Our ref: DOC20-250862
Senders ref: SSD-9549

Subject: Jindera Solar Farm (SSD 9549) - Response to Submissions

ATTACHMENT A – BCD assessment summary for Jindera Solar Farm (SSD 9549) – Response to Submissions

ATTACHMENT B – Detailed comments for Jindera Solar Farm Submissions (SSD 9549) – Response to Submissions

Figure 2-9 Location Map

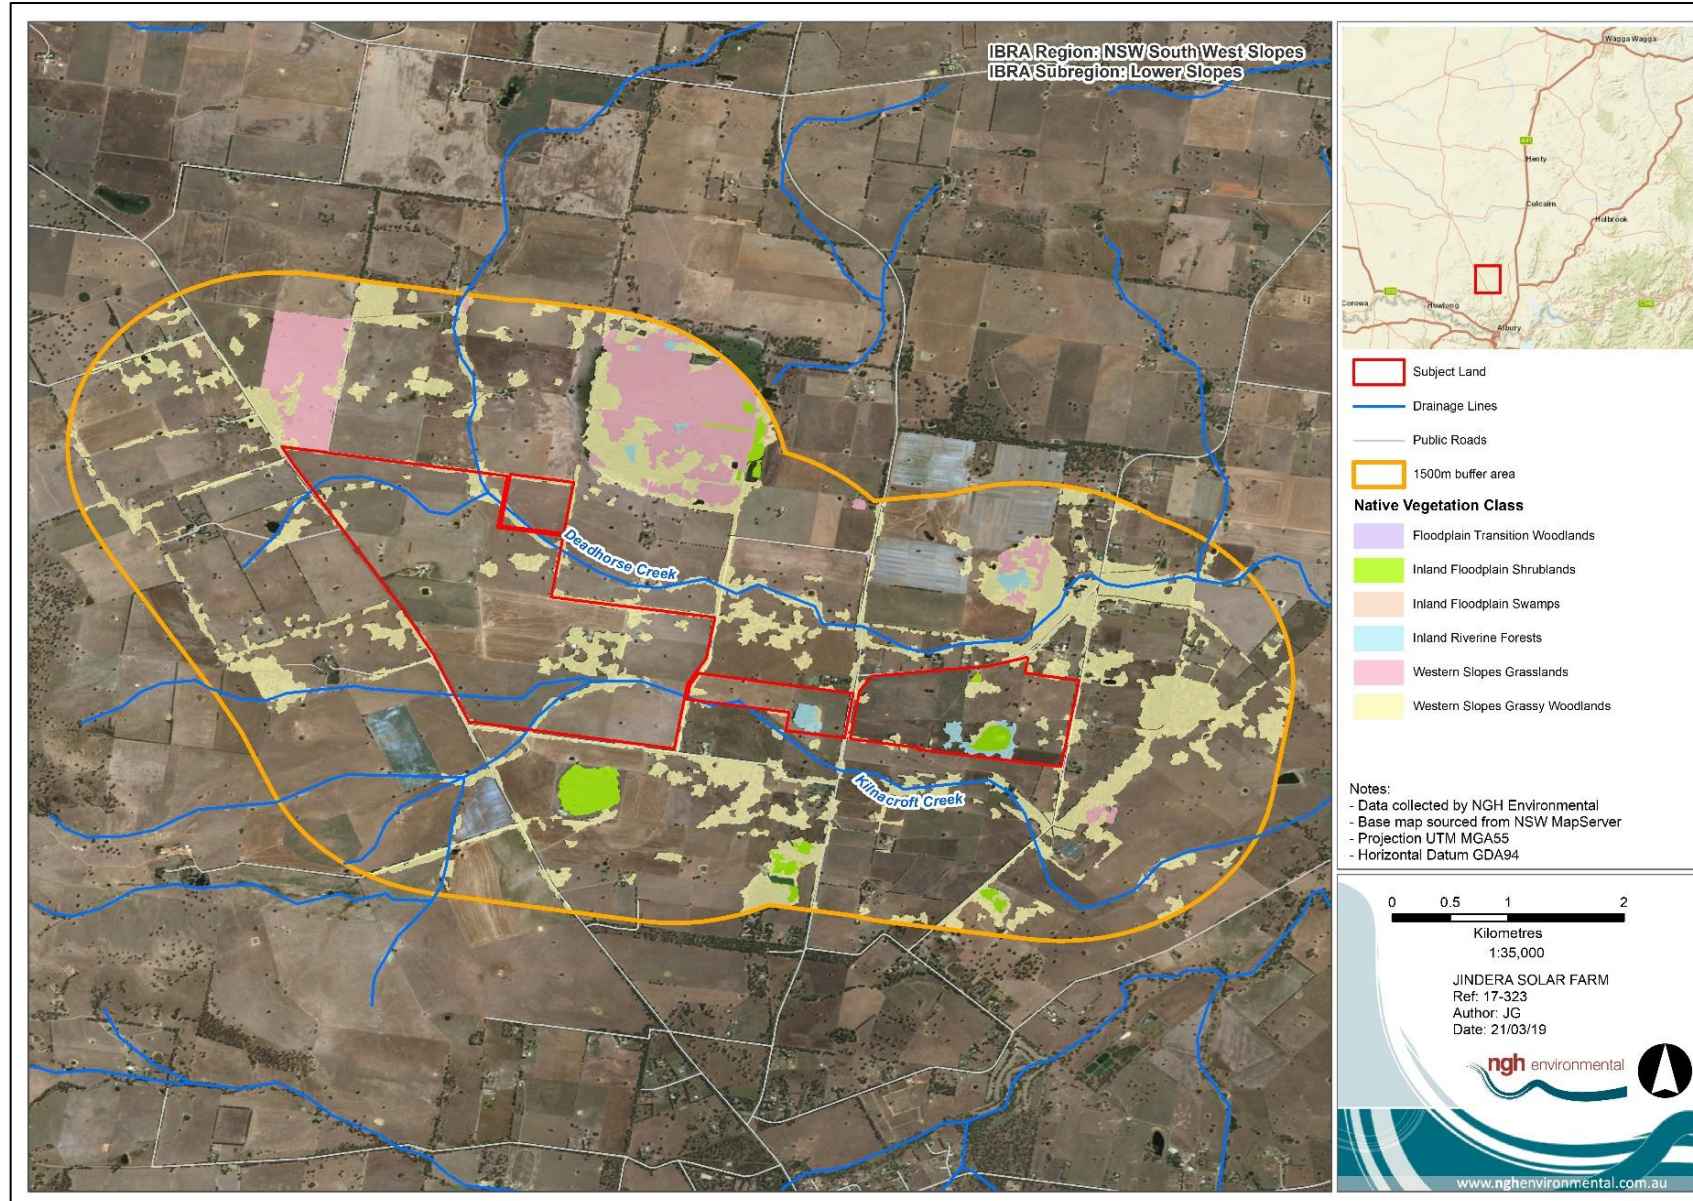
ss.4.2.1.9 of the BAM requires the assessor to identify the connectivity of different areas of habitat that may facilitate the movement of threatened species across their range and identify these on the Location Map. This work should include scattered paddock trees and category 2 regulated land associated with zone 10.

We are **not satisfied** that the revised BDAR establishes the focal populations of threatened species, their patches of habitat, nor the size or location of source populations, nor the distances between them, both on and off the development site. Examples include the Squirrel Glider (*Petaurus norfolcensis*) and the Flame Robin (*Petroica phoenicea*). Without this information it is not possible to assess the impact of the proposal on the connectivity of threatened species consistent with ss.4.2.1.9 of the BAM. Similar information is also lacking for other threatened species including those assumed to occur on the subject land including the Southern Bell Frog (*Litoria raniformis*).

Figure 2 Development site and land categorisation (Source ESRI)

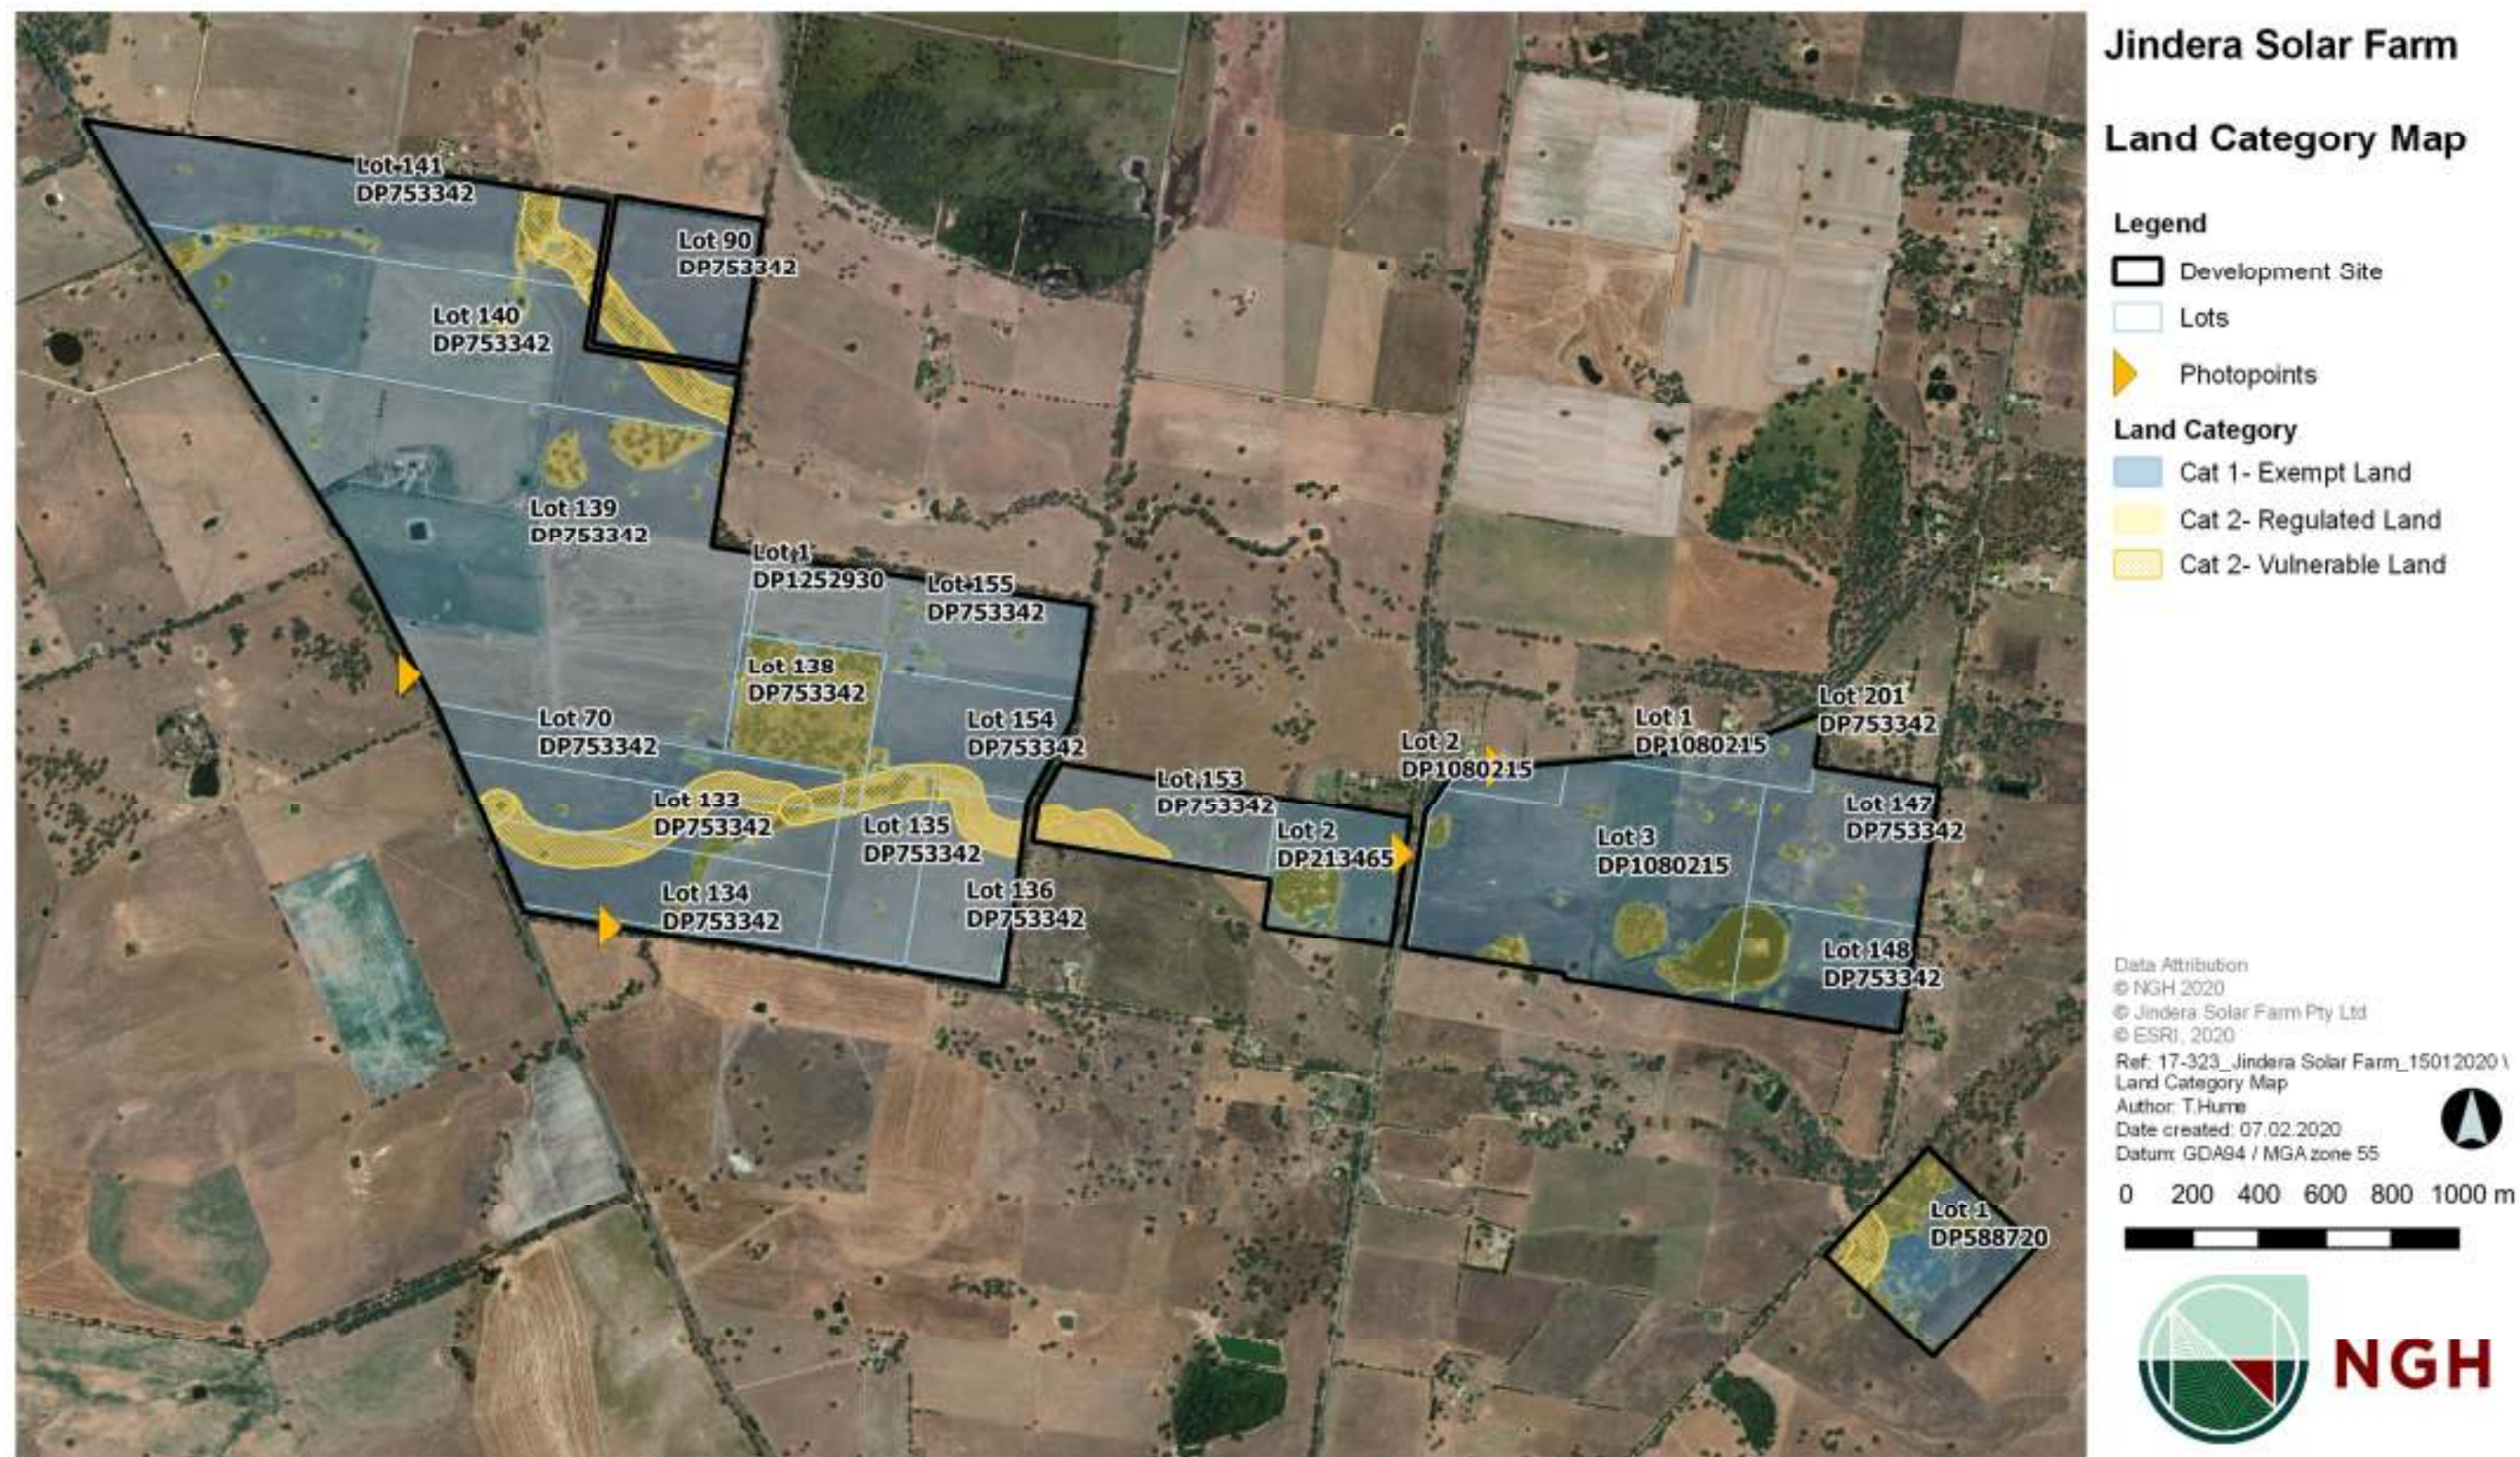
The applicant describes the method used to determine category 1 exempt regulated land. The applicant has generated a draft map of category 1 and category 2 land, but that map has not been provided consistent with Appendix 10 of the BAM.

The correspondence at Appendix J dated 20 February 2020 includes a series of aerial images showing the extent of native vegetation on the subject land dating to 1990. We consider this as evidence that the majority of zone 10 is also category 1 exempt regulated land. As such it can be disregarded from the BAM, but not from assessment of prescribed impacts.

We are satisfied that criteria used in Table 1 of that correspondence relies on the presence of native vegetation since 1 January 1990 to determine the extent of category 2 regulated land. Those criteria being land where native vegetation is present since 1 January 1990, where native vegetation is not present since 1 January 1990, where native vegetation is grazed or protected, or where the land is otherwise mapped as category 2 regulated land by the Native Vegetation Regulatory Map.
